**Washington State
Department of Transportation**

August 26, 2014

Subject: BL-14-00014 - Sukert
SR 903 milepost 4.2 right

We have reviewed the proposed boundary line adjustment and have the following comments.

PROPOSED LAYOUT

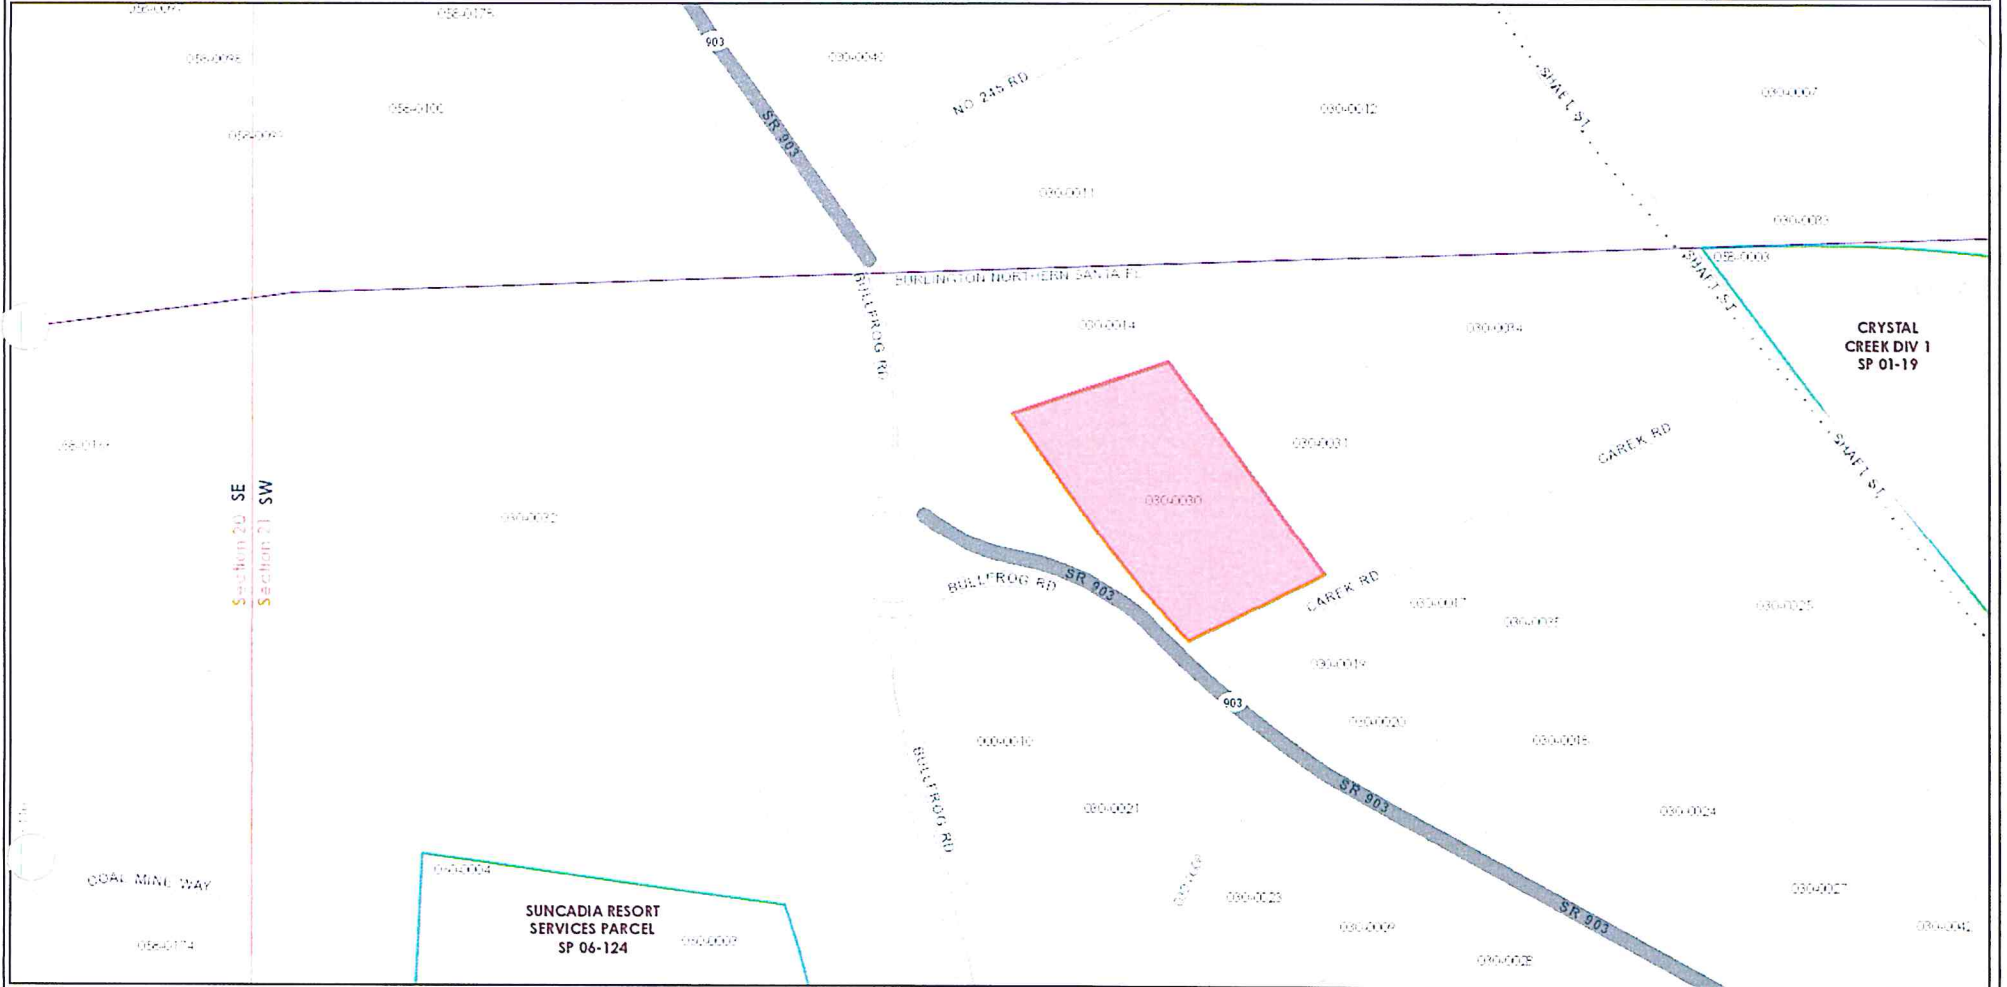
The proposed project is adjacent to the SR 903 / Bullfrog Road intersection. SR 903 is a managed access class 4 highway with a posted speed limit of 35 miles per hour. Direct access to the highway within the roundabout's area of influence is prohibited. Access to the proposed lots must remain via Carek Road.
